# **Building Code of Australia**

## **Assessment Report**

**Project Address: 1 Alfred Street, Sydney**

Report Number: 152779 – Tower B

DRAWING TITLE:			
BASEMENT 3 - RESIDENTIAL			
DATE:	SCALE:	DRAWING No:	REV:
18.01.2019	As indicated @A1		
DRAWN BY:	PROJECT NO:	1003	G
SS. SMS. VS. XM	CA3845

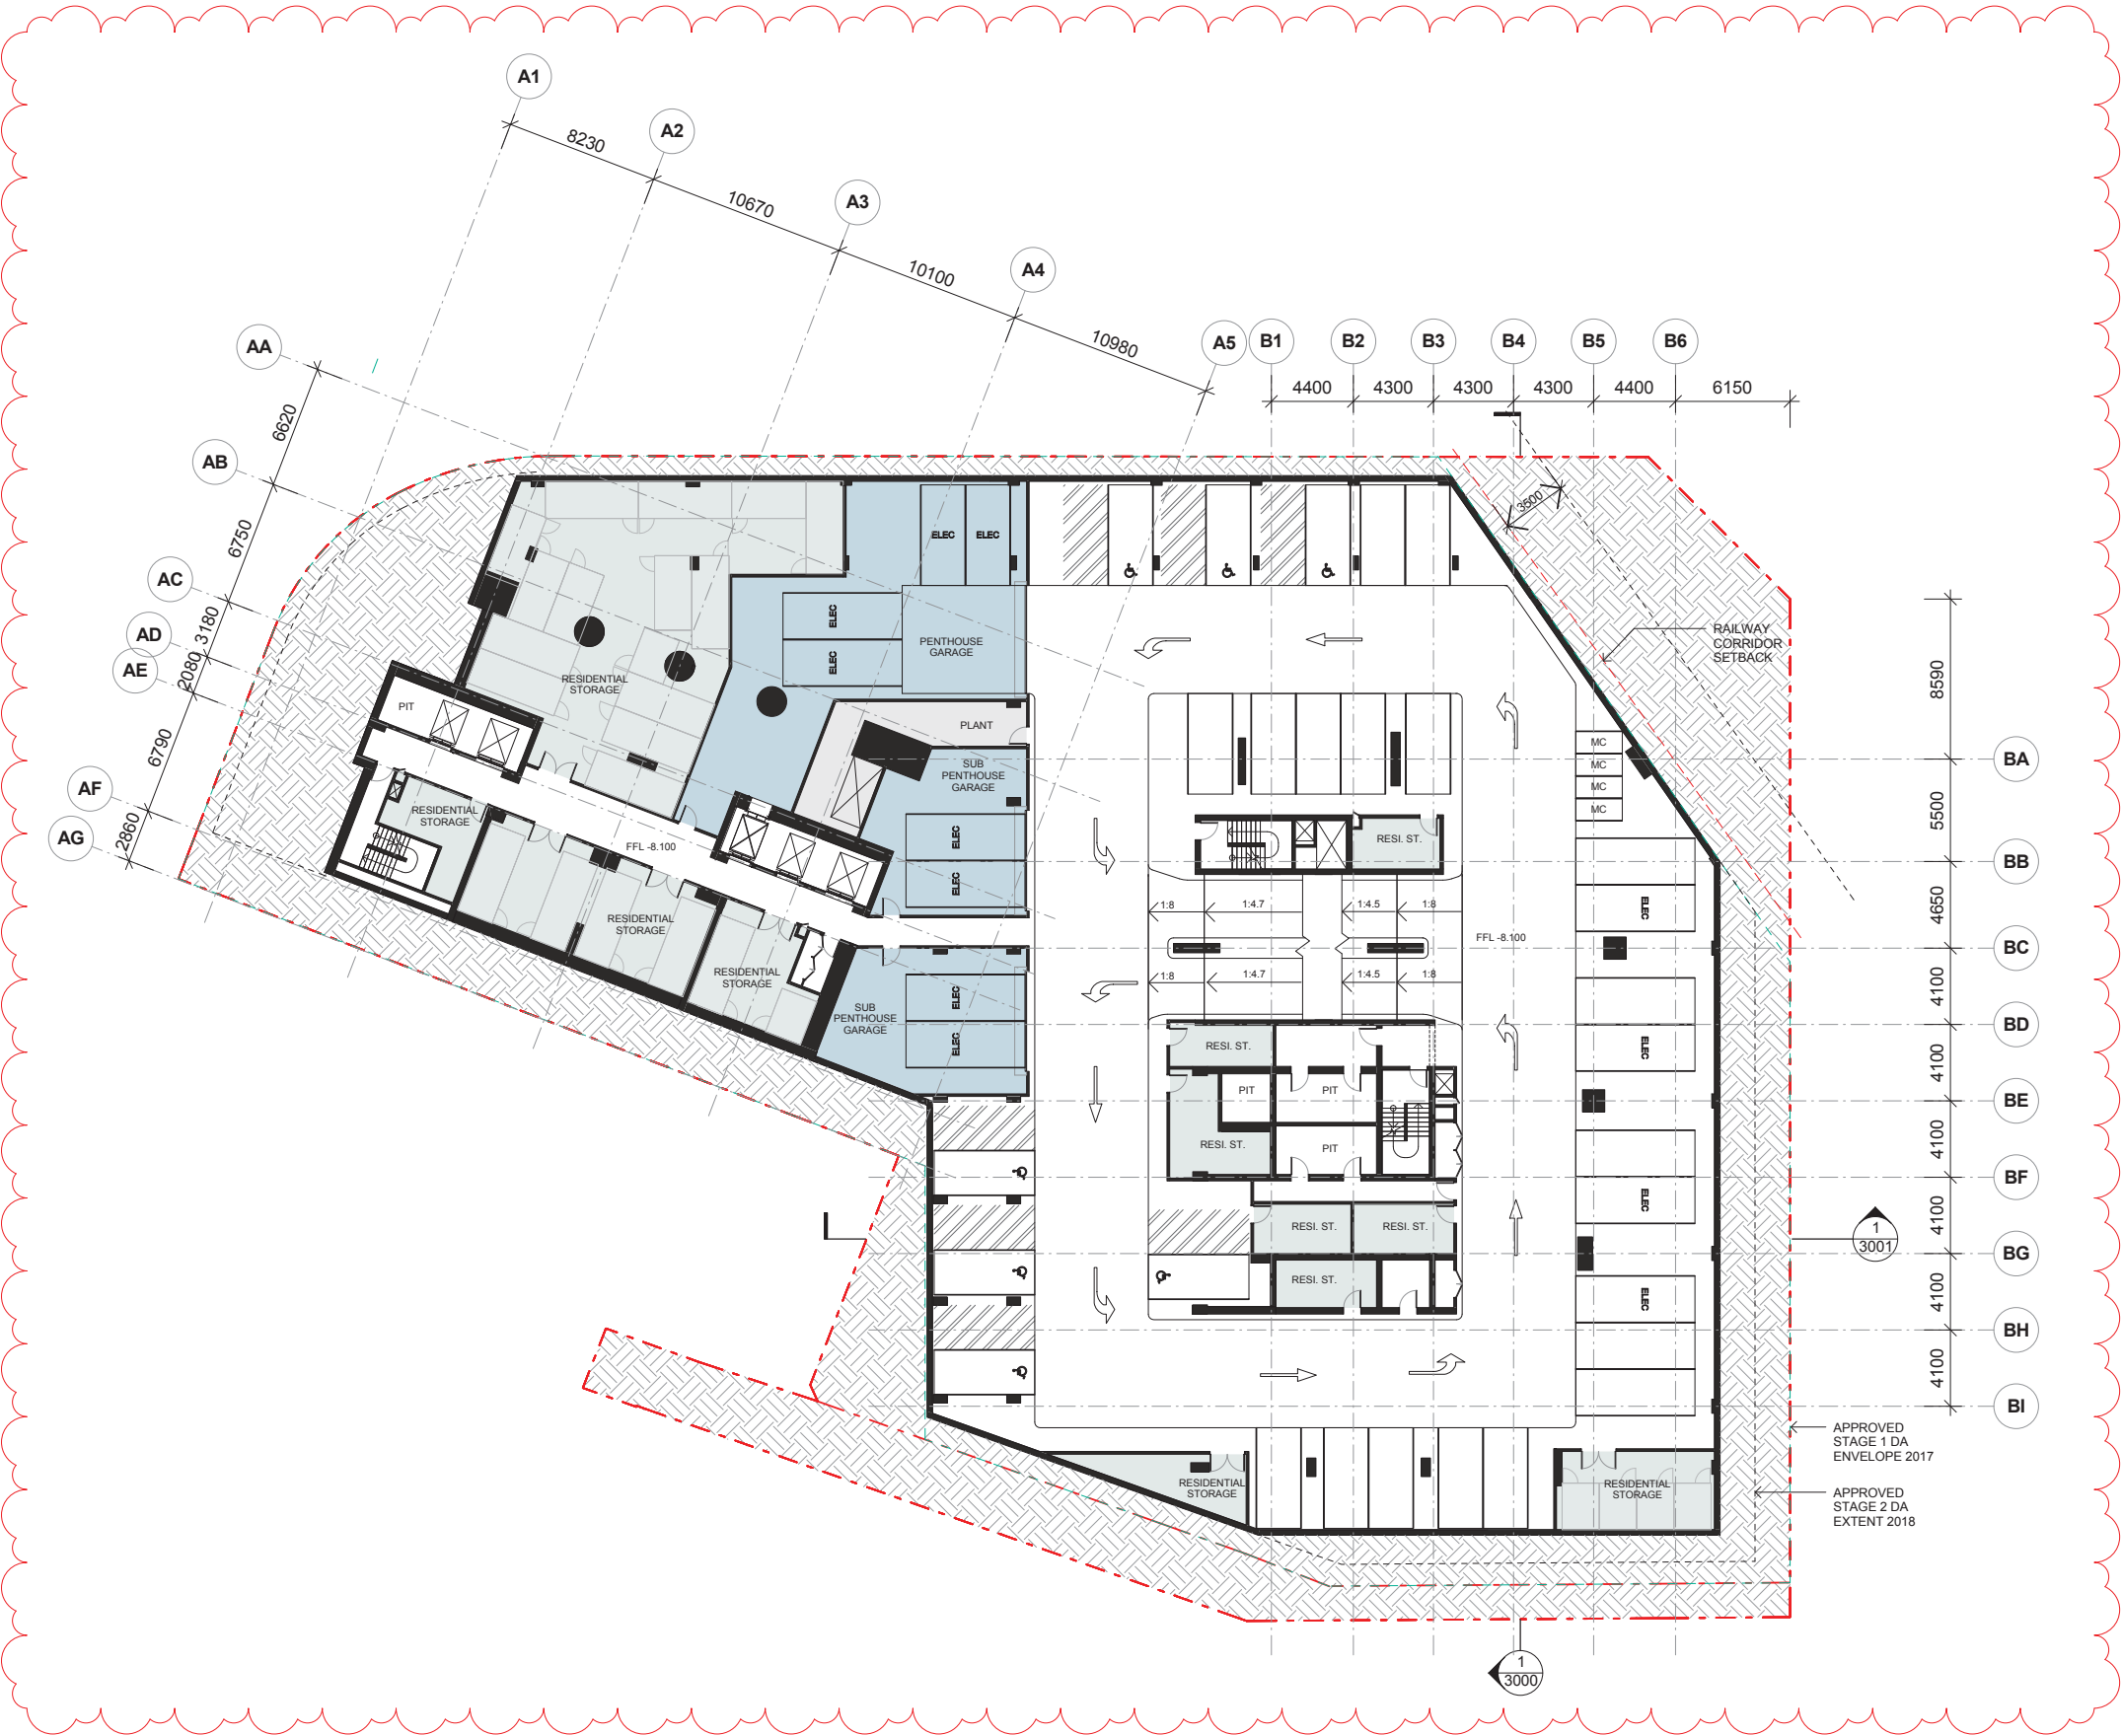
### **Basement 3, 4, 5 and 6**

Sub penthouse garage is more than 20m to a point of choice (23m, 28m in Basement 3).

DRAWING TITLE:
BASEMENT 1 - LOADING & BOH
DATE: 18.01.2019 SCALE: 1:200 @ A1 DRAWING No: 1005 REV: H
DRAWN BY: SS.SMS.VS.XM PROJECT NO: CA3845

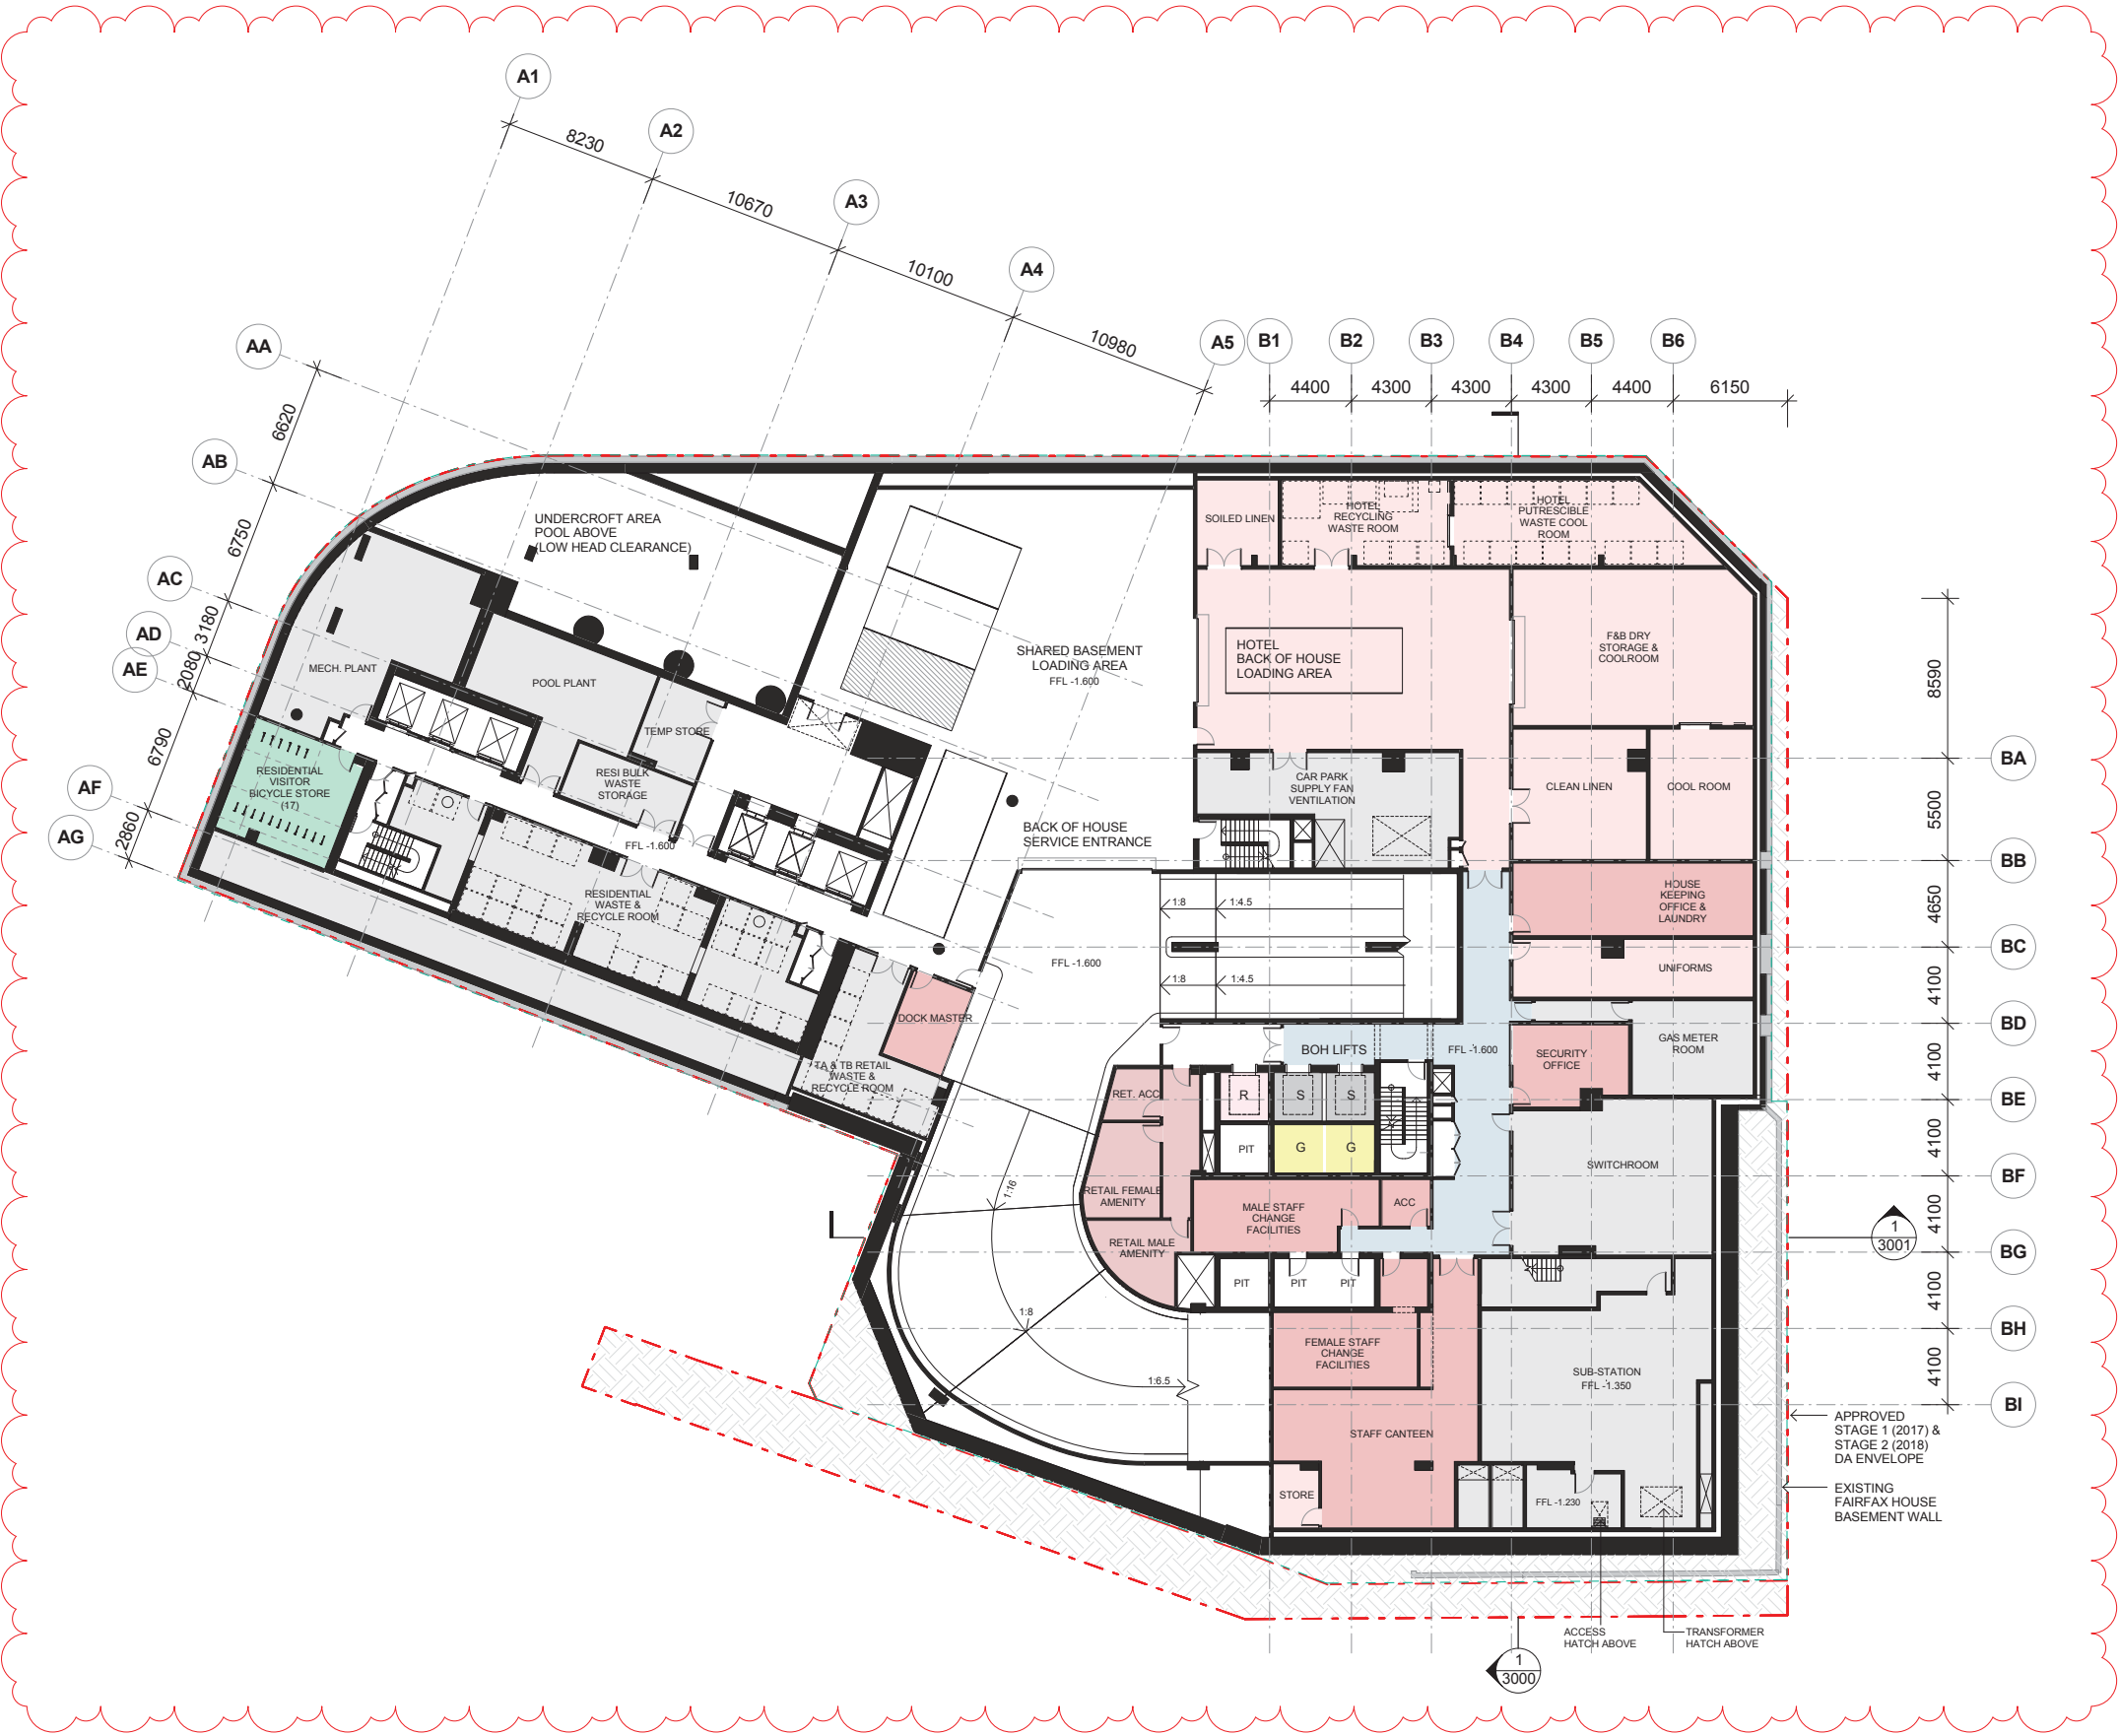
### Basement 1

- i. Distance to a point of choice from Retail Male Amenity and Male Change Facilities is more than 20m (24m).

- ii. Distance to point of choice from Store in Staff Canteen exceeds 20m (29m).
